Ribble Valley Borough Council
Housing & Development Control

Application no: **3/2023/0056**

Address: **Phynis Farm Catlow Road Slaidburn BB7 3AQ**

Proposal: **Proposed conversion of former farm buildings to form four dwellings including the change of use of land to form private curtilage areas and the remodelling of the central courtyard.**

drawing title	Site Plan As Proposed
scale @ A3	1:200
date	07.11.2022
dm	JT
chk'd	RR
drawing number	1541-009
sheet number	A

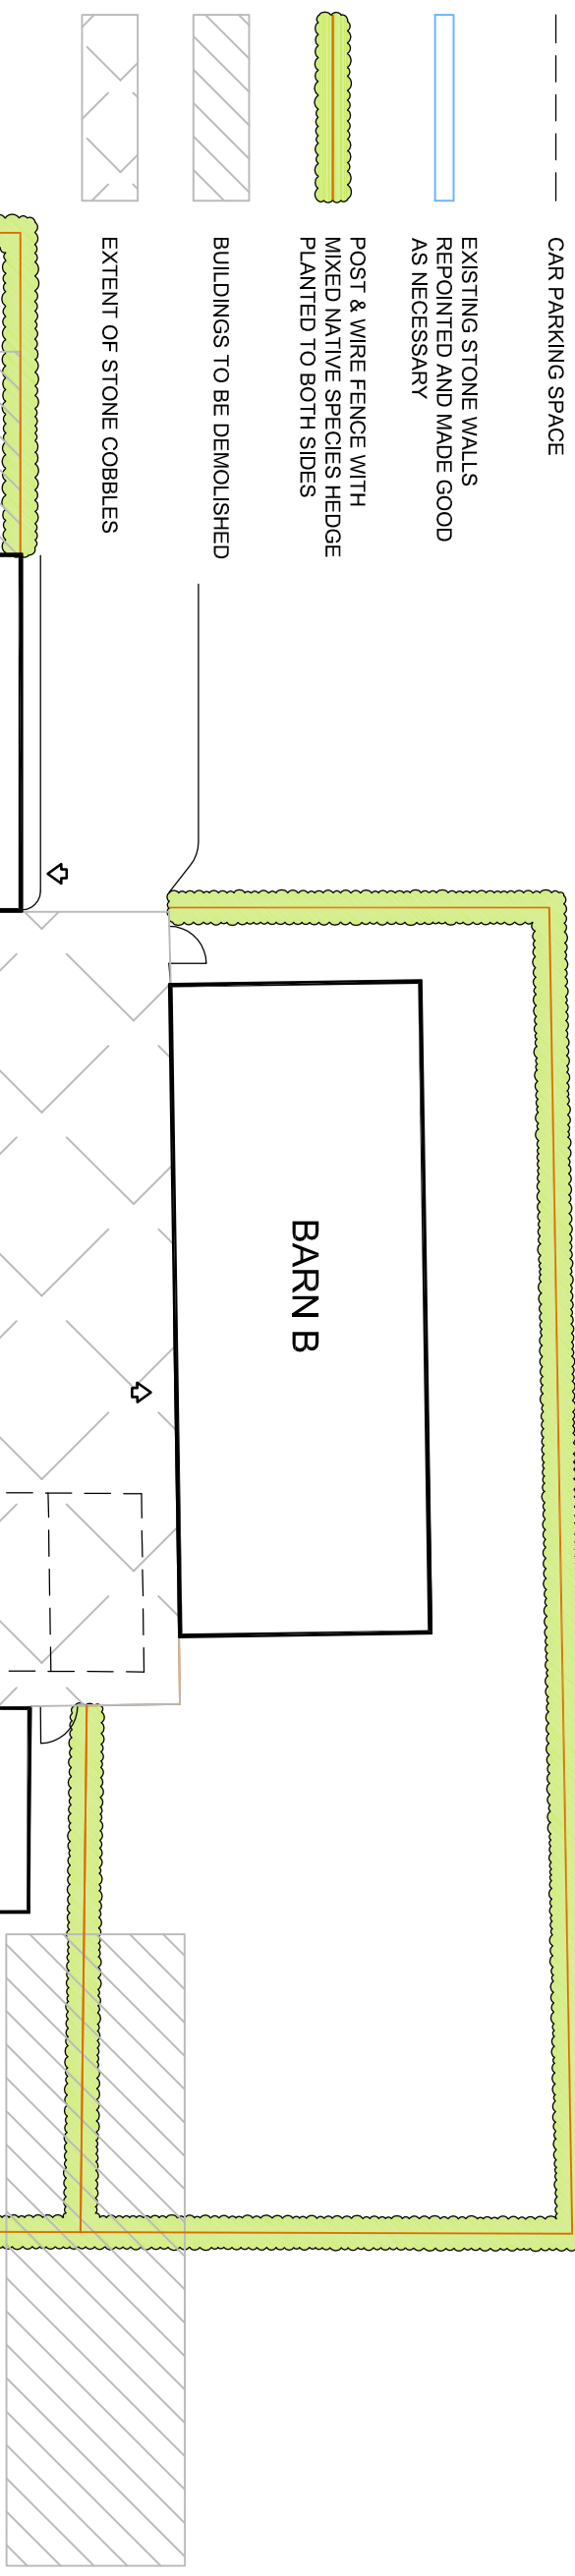
The LHA, however, have reviewed the shared courtyard where the parking spaces will be located and advise that the car parking spaces for Barn C are relocated. This is because the spaces are currently approximately 2m away from the internal access which serves the courtyard. Therefore, to ensure that there is adequate space should a vehicle be entering and for a vehicle leaving these spaces, Barn Cs parking area should be relocated. The LHA advise that the spaces should be located on the same alignment as Barn As car parking spaces or in the centre of Barn C.

The LHA also advise the Agent that the internal access from the farmhouse to the internal courtyard should be widened to allow two-way movements to occur. Currently, as vehicles enter the courtyard, the internal access width is approximately 2.7m. Therefore, the LHA advise that this is widened to 4.25m given the courtyard serves 4 dwellings.

drawing title  
**Site Plan As Proposed**

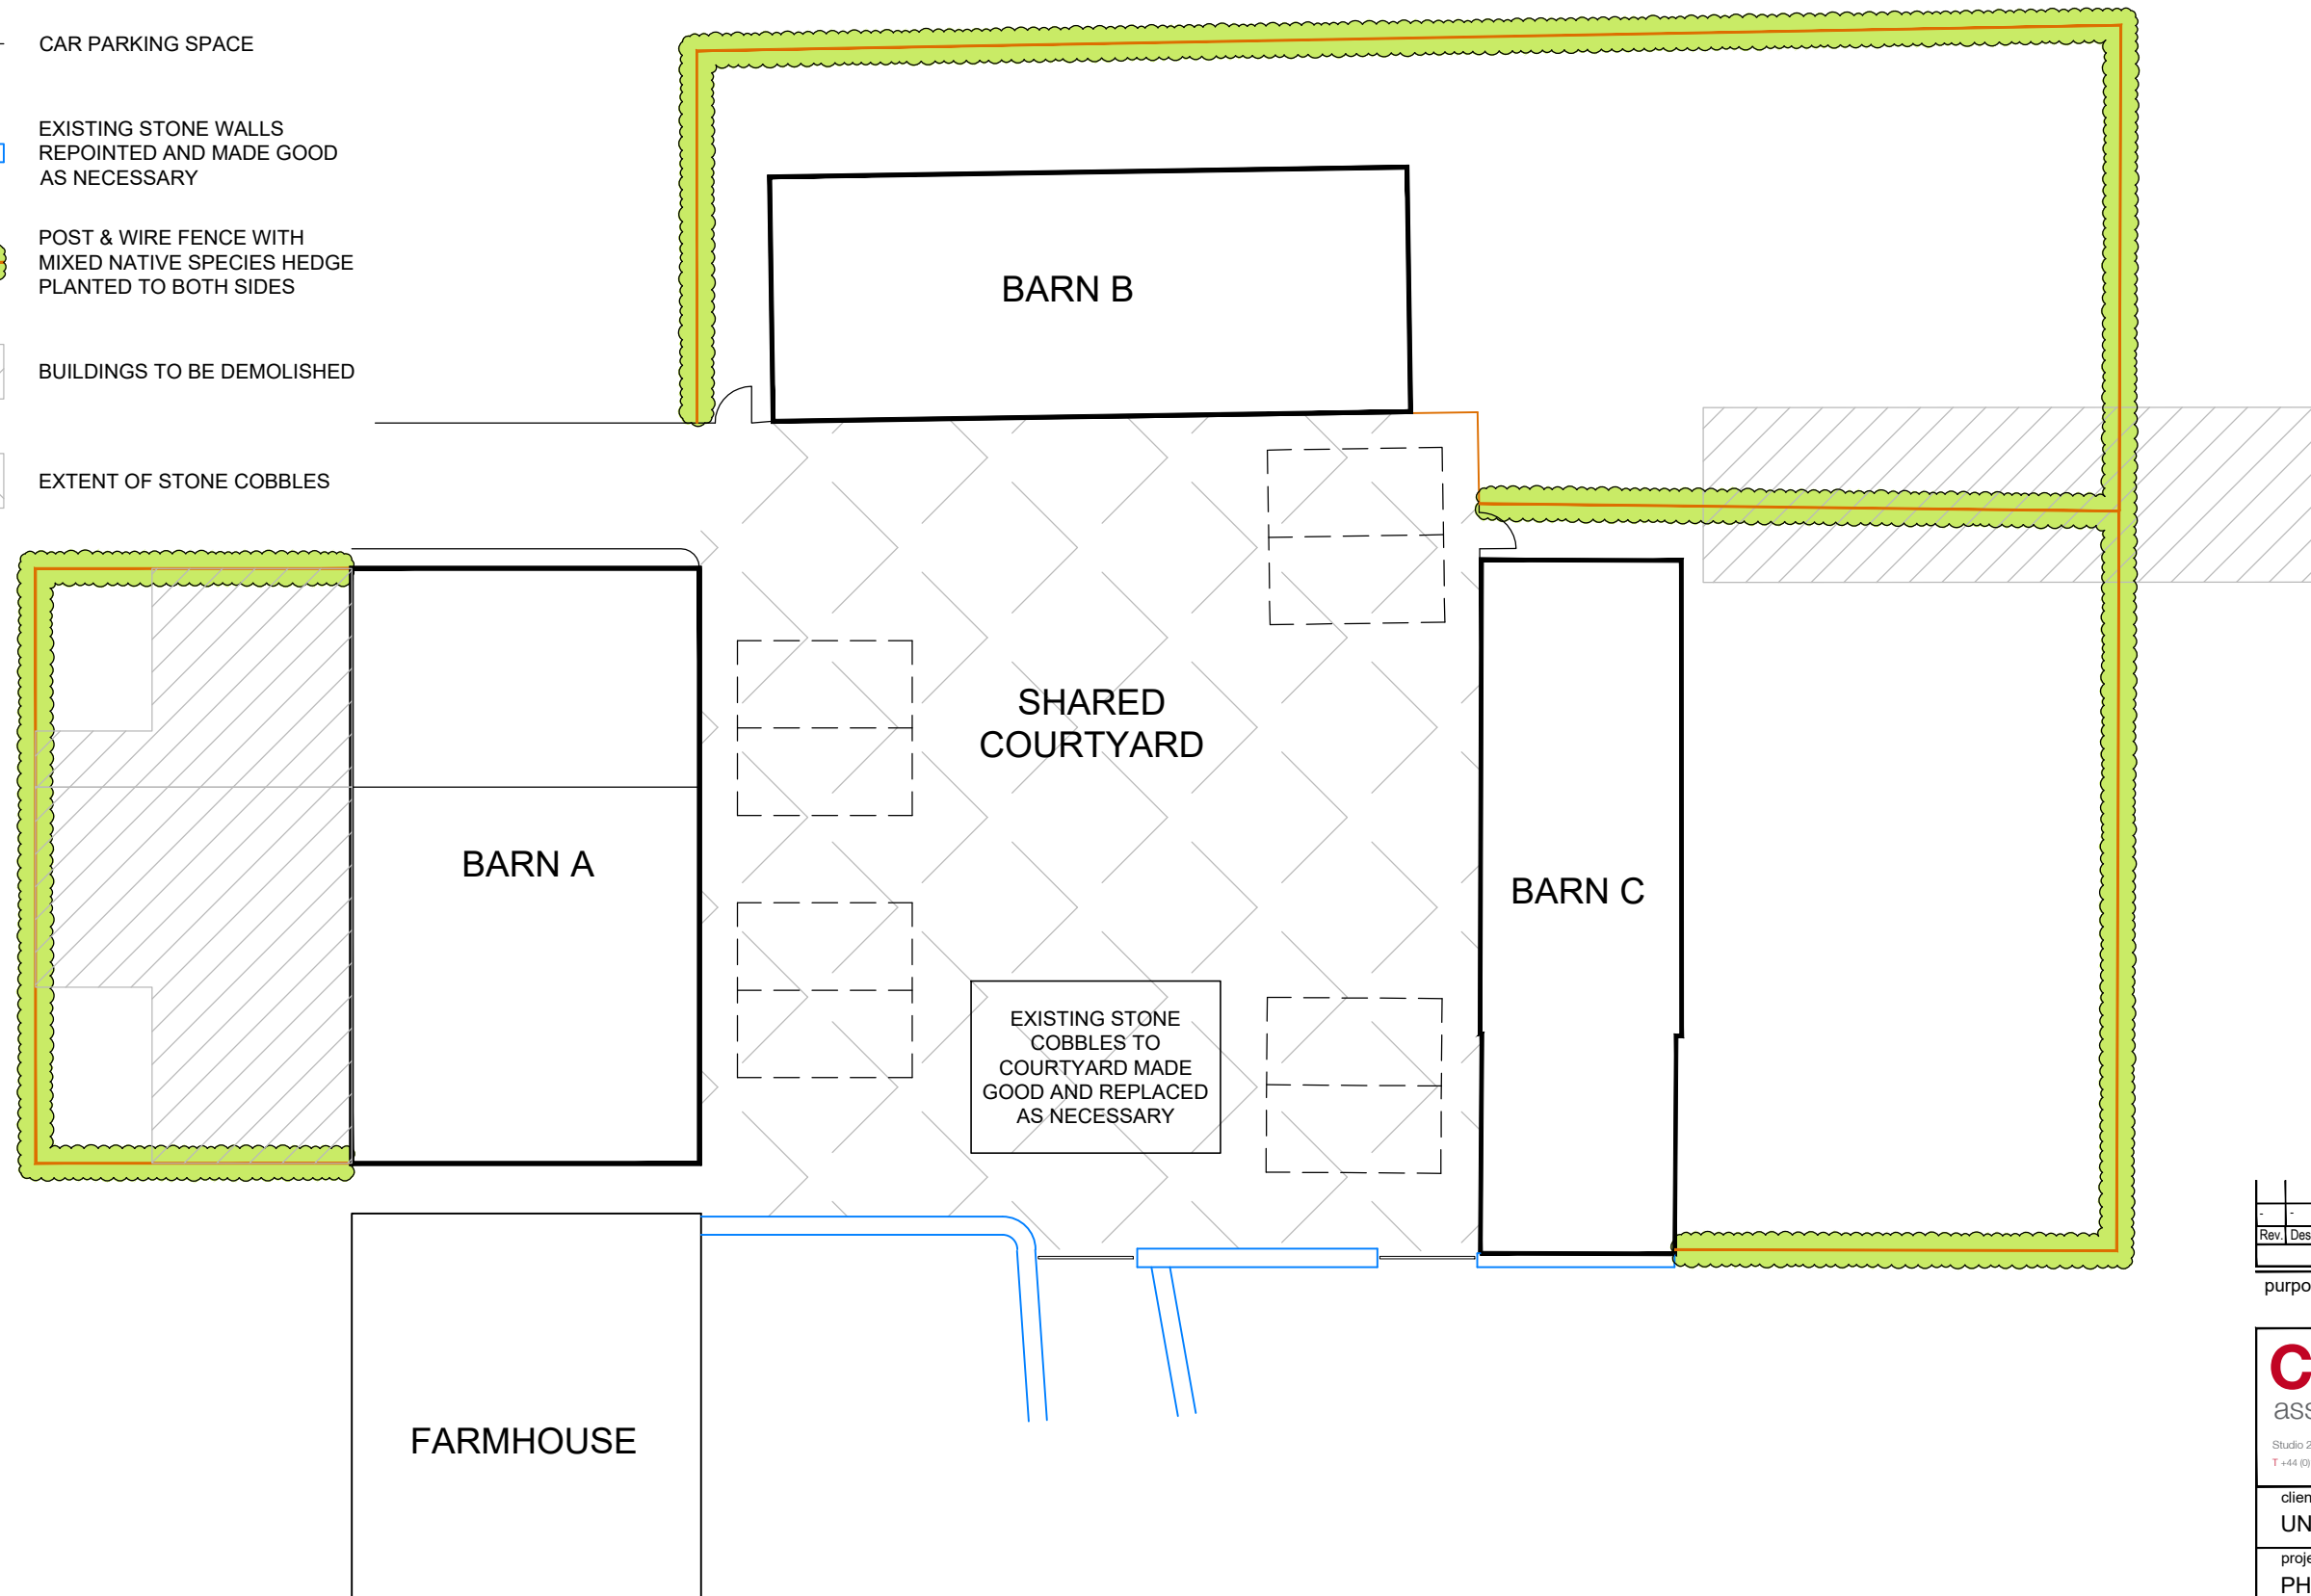
The LHA have reviewed Cass drawing number 1541-009 titled "Site Plan As Proposed" and are aware that each dwelling will have 2 car parking spaces each. This complies with the LHAs parking guidance as defined in the Joint Lancashire Structure Plan given the number of bedrooms each unit will have.
